Our ref: NO/2013/105263/02-L01
Your ref: 3/2013/0448
Date: 10 April 2014

PROPOSED POULTRY UNIT

OAKFIELD, LONGSIGHT ROAD, CLAYTON-LE-DALE

Proposed Site Plan

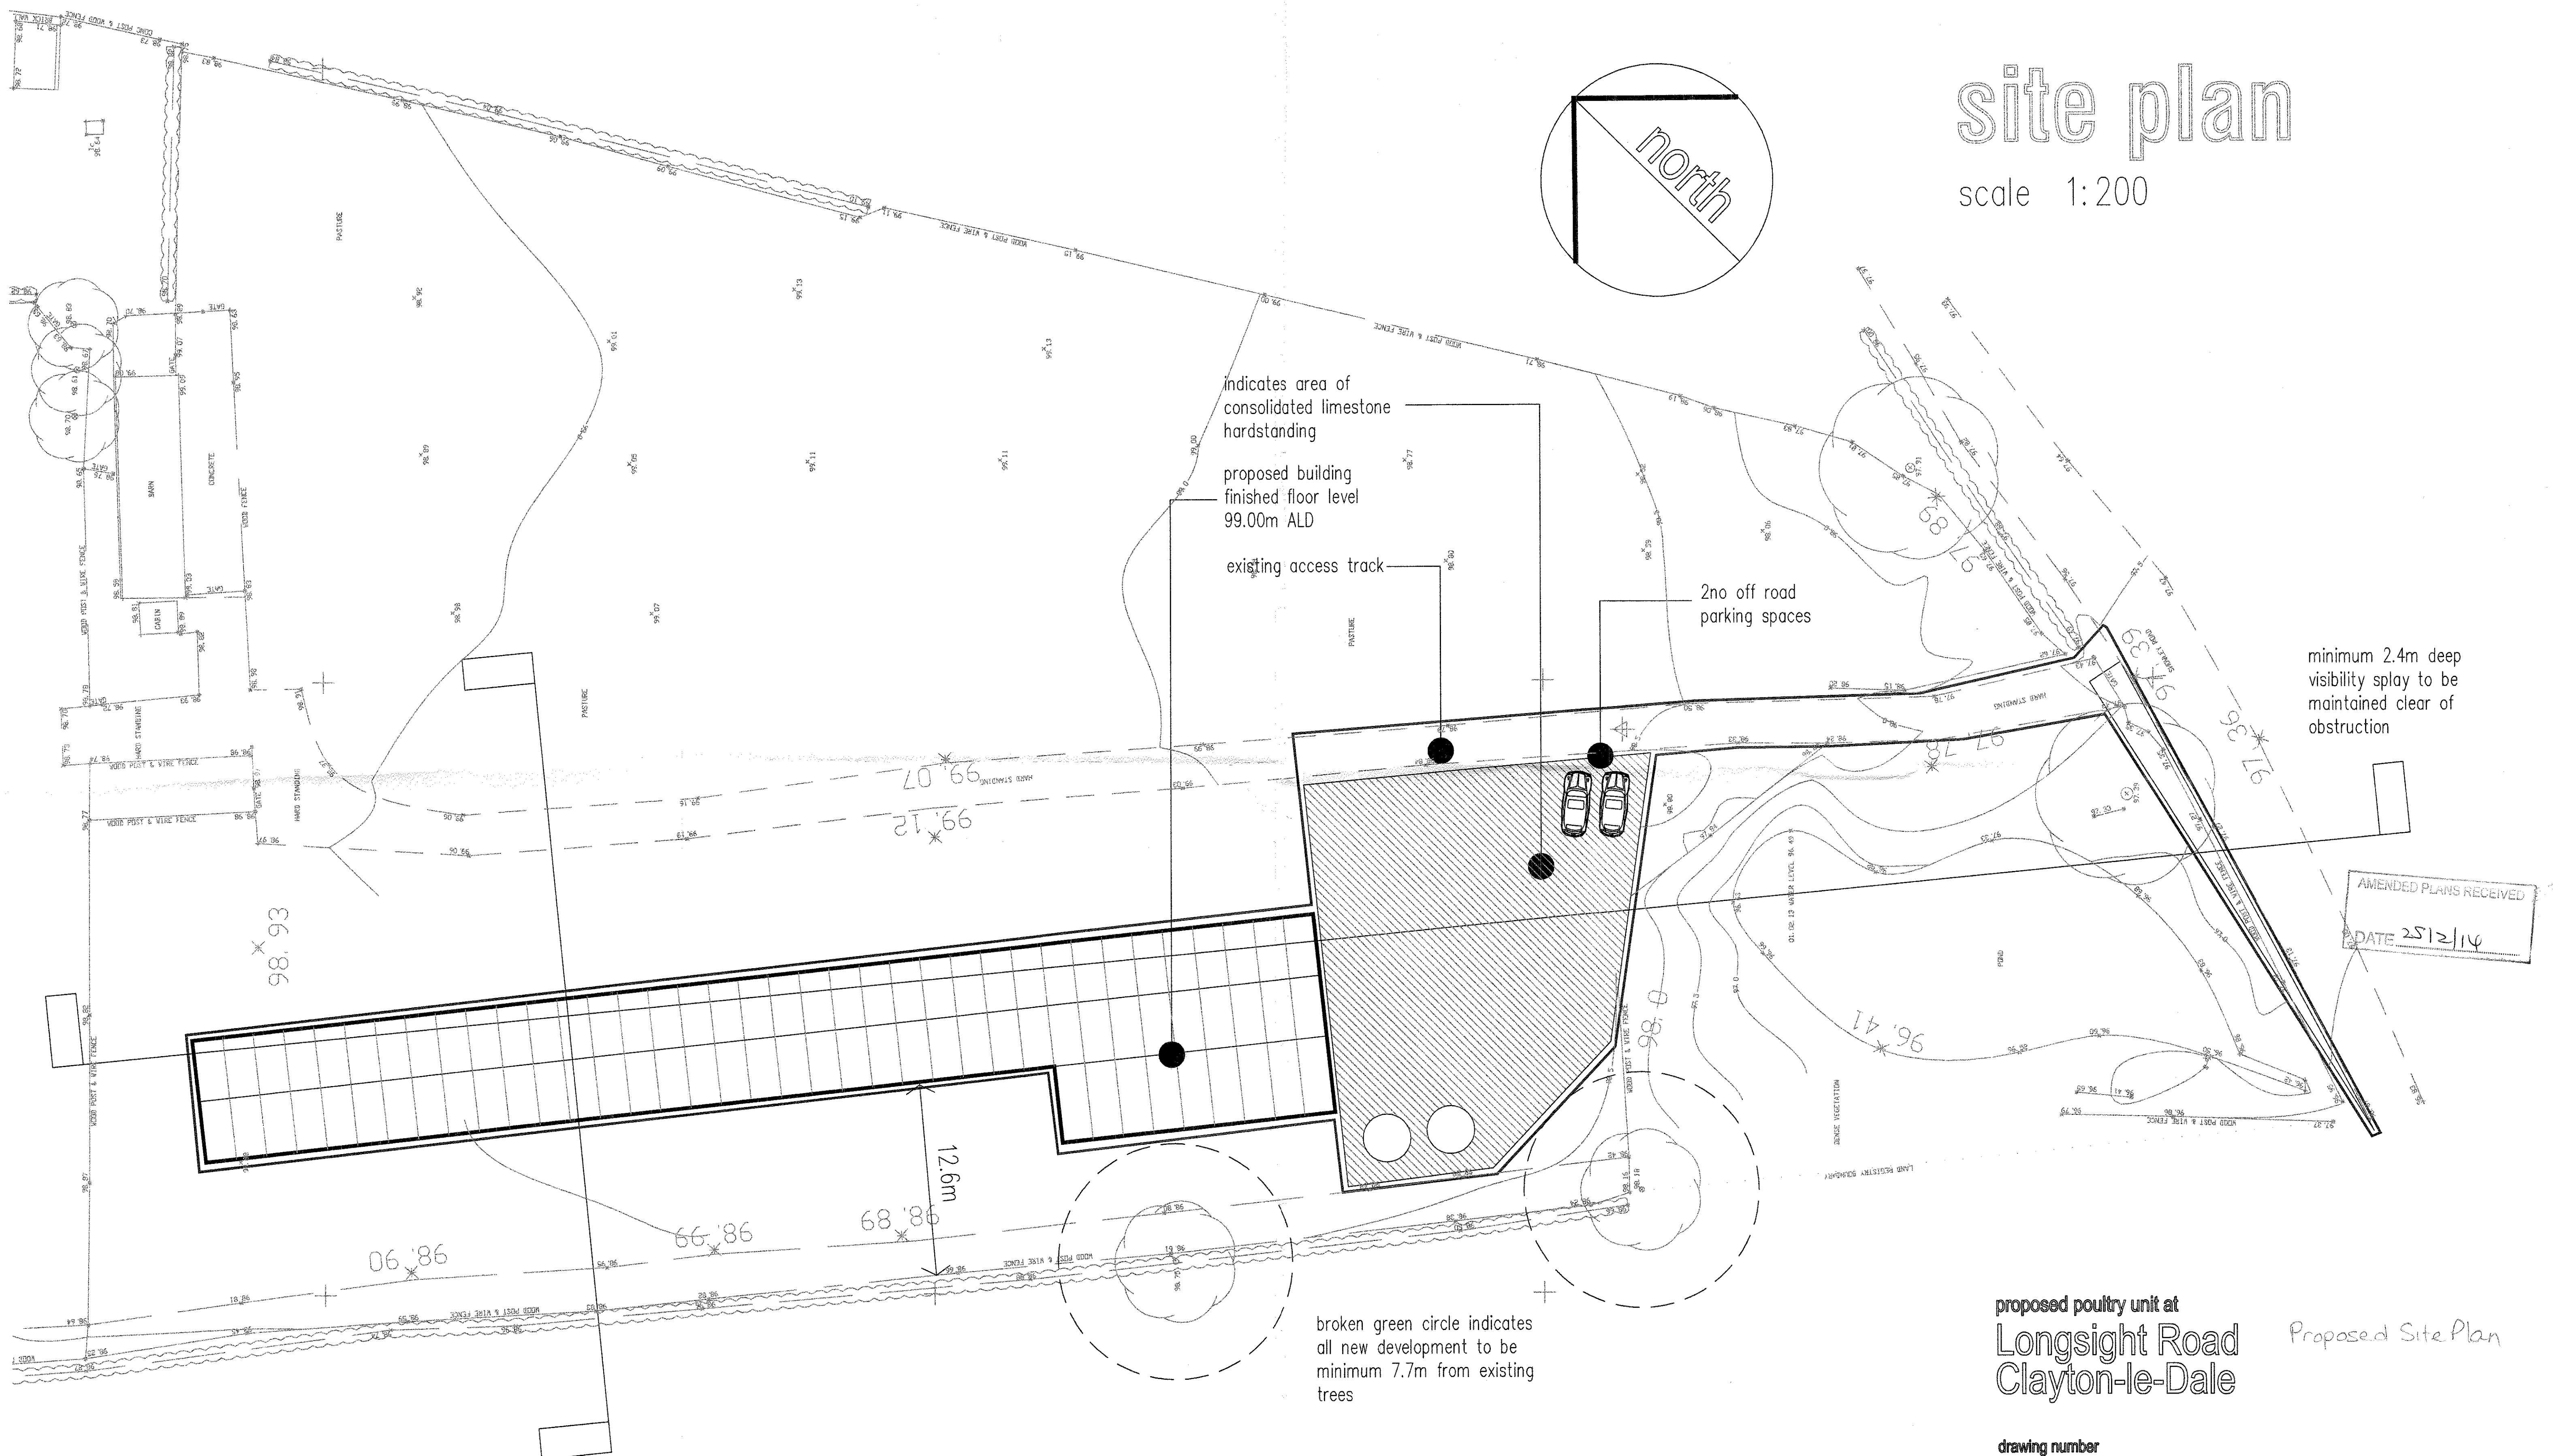
The applicant proposes to store manure directly on an enclosed trailer, which is not acceptable. All stored manure should be properly contained and directed into a well designed and constructed store with effluent collection systems, or a temporary field

heap with minimal risk of run-off or pollution to groundwater.
